Our Ref: AK/19-156-22952

Date 6th Oct 2020

Re : Land at Stakers Farm, Yapton – Y/72/20/RES

Further to the e-mail of the 22nd September 2020 containing drainage queries we would like to provide additional information to address these.

PERMEABLE PAVING CONSTRUCTION DETAILS

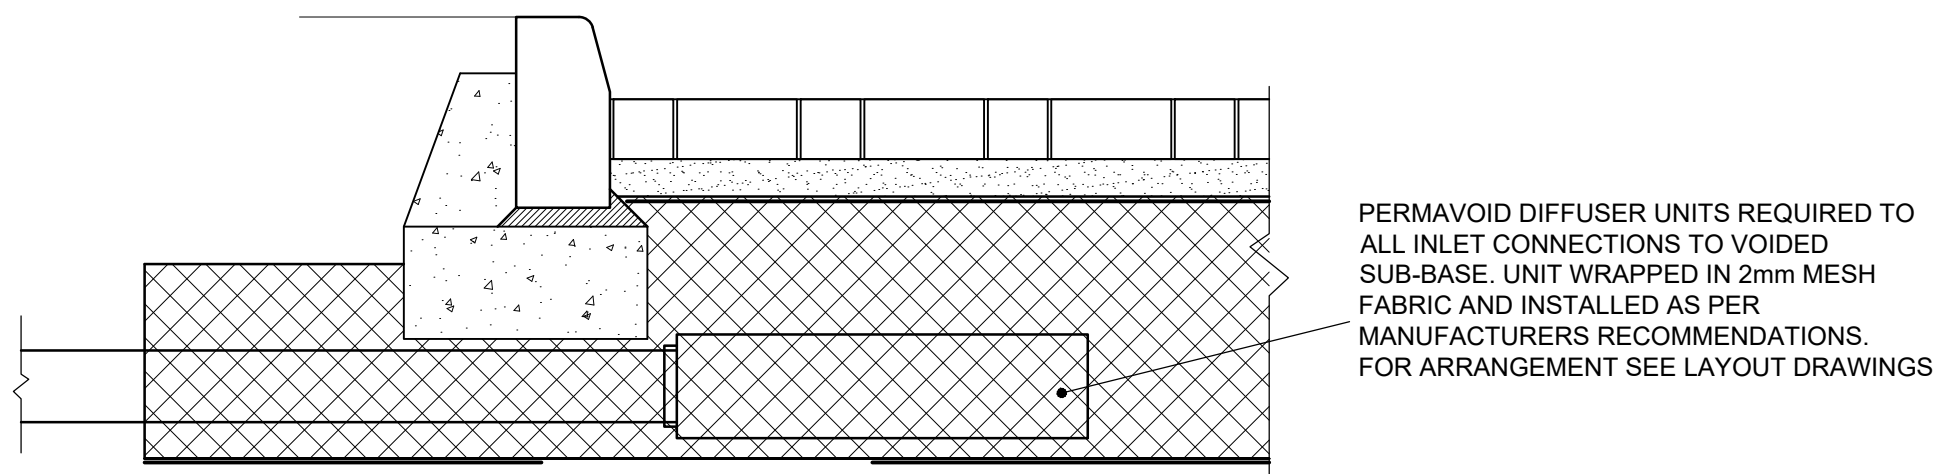
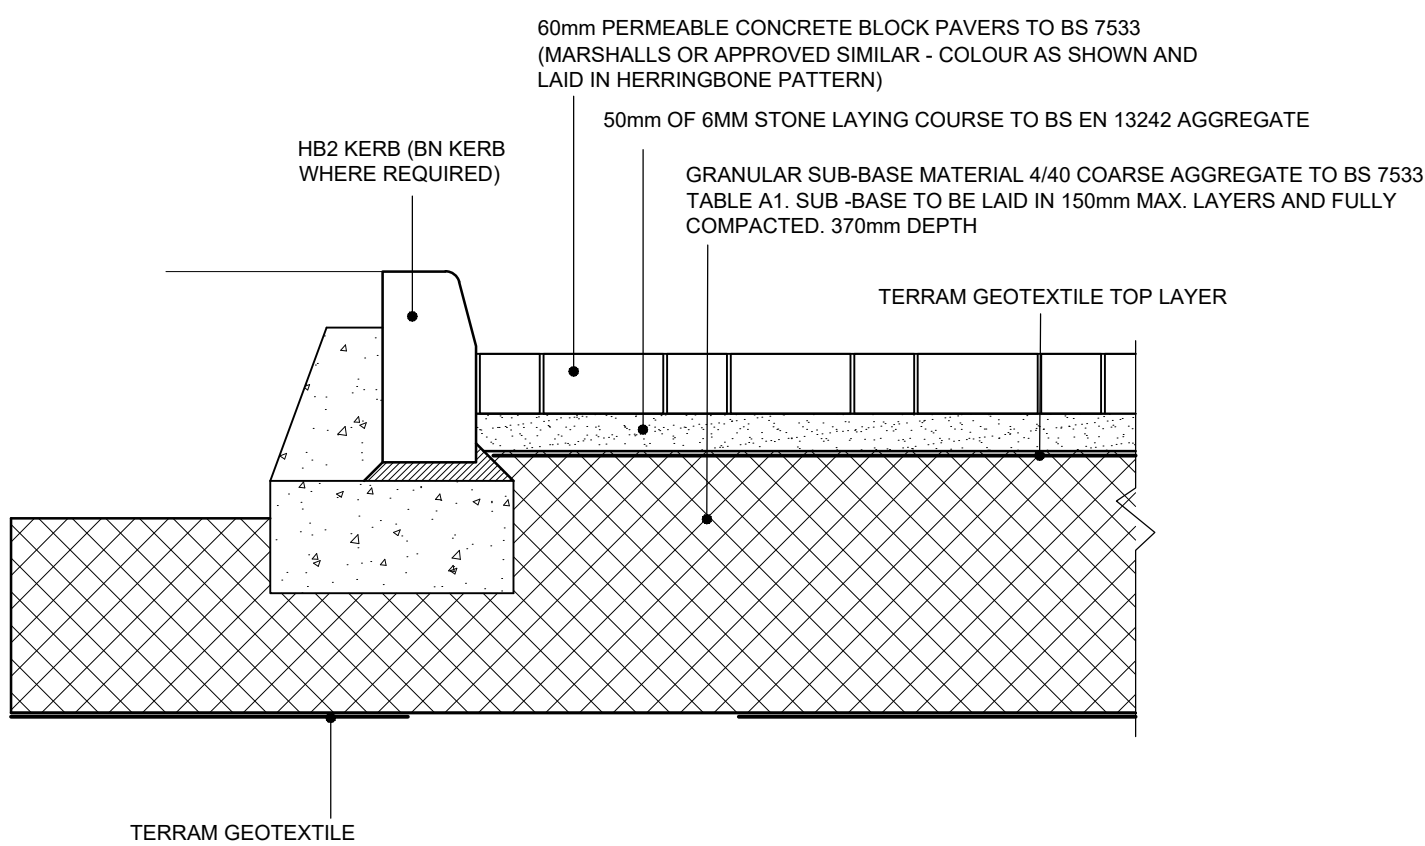
4. *“Please clearly indicate on plans where the different permeable paving types shown on the construction drawing are proposed* - Please refer to drawings: YAP-150-72A, YAP-150-73A and YAP-180-35.

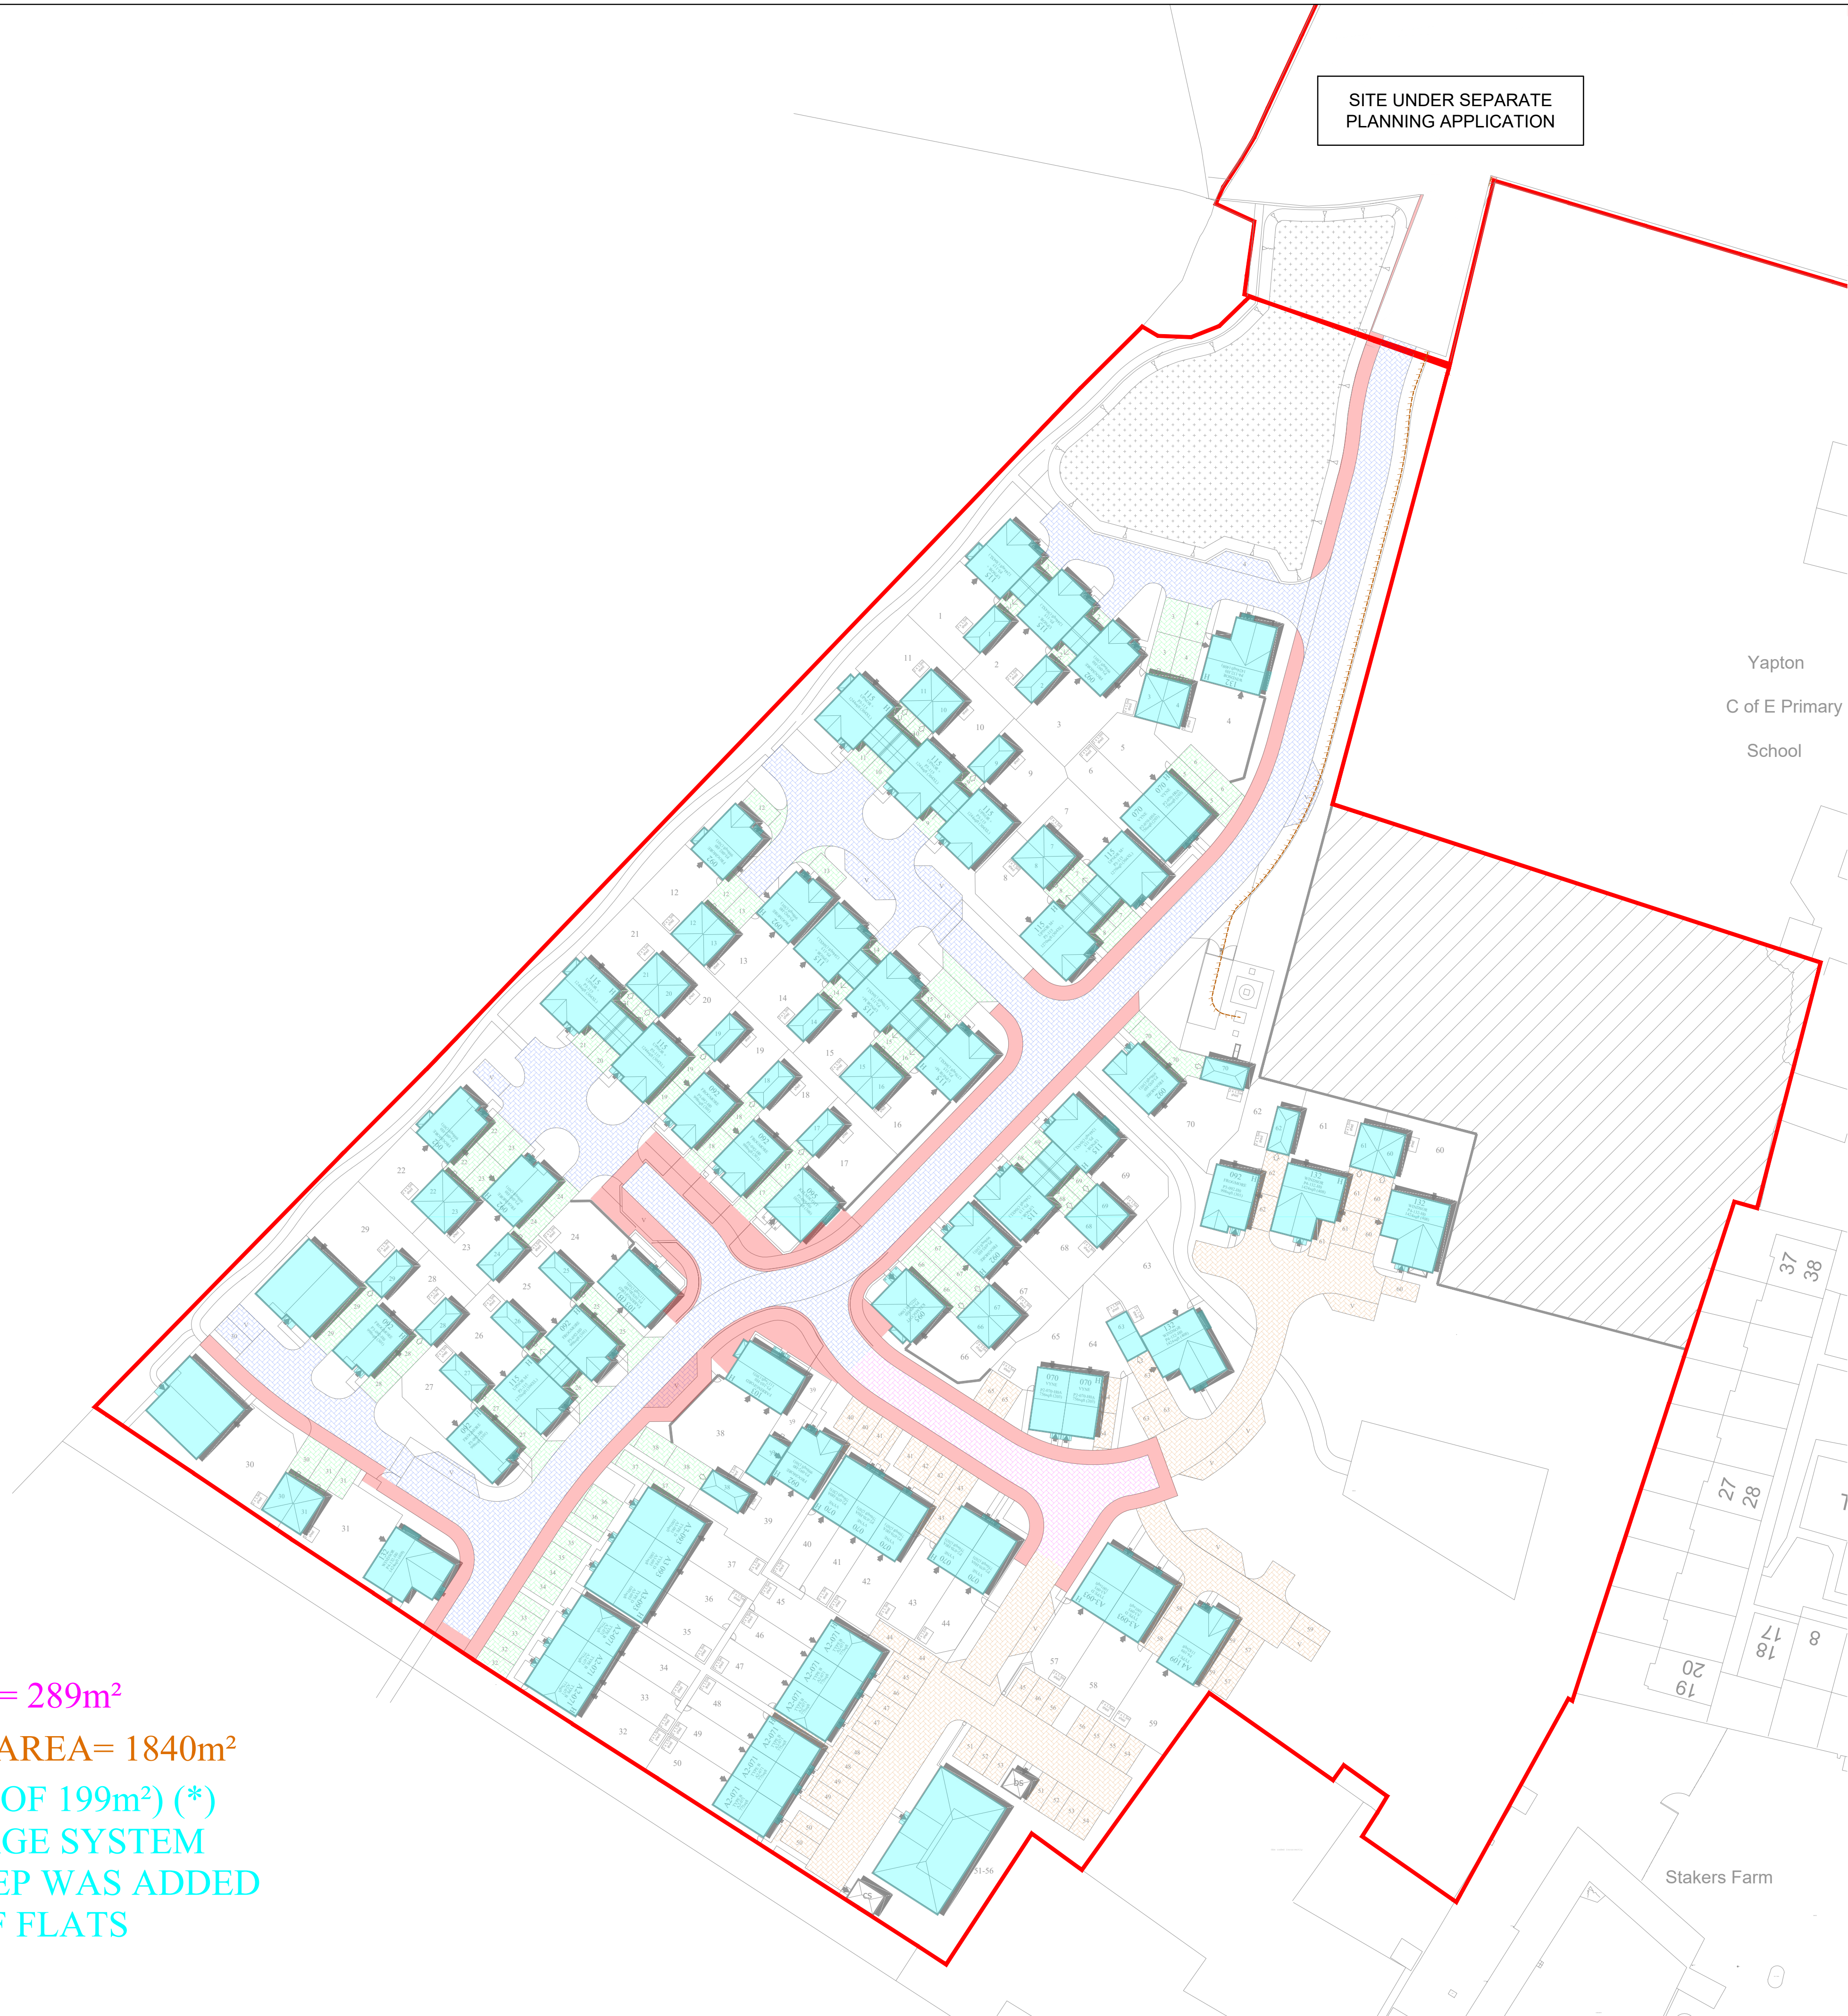
3. *"Please provide impermeable areas plans that clearly show the areas draining to each surface water drainage feature. Preferably provide these in dwg to facilitate paperless review"*. – The overall areas are identified and measured on drawing YAP-130-25A (also provided in .dwg format for paperless review as requested). The Microdrainage printout "Land at Stakers Farm, Yapton_70 Units_SW network_revA" specifies roof areas contributing to each part of the network system and ultimately discharging into infiltration blanket. Permeable paving system caters for itself with its levels shown on drawing YAP-130-26A and full modelling with contributing areas presented on Microdrainage printout "Land at Stakers Farm, Yapton_70 Units_Permeable Paving model_revA_(excluding private drives)".
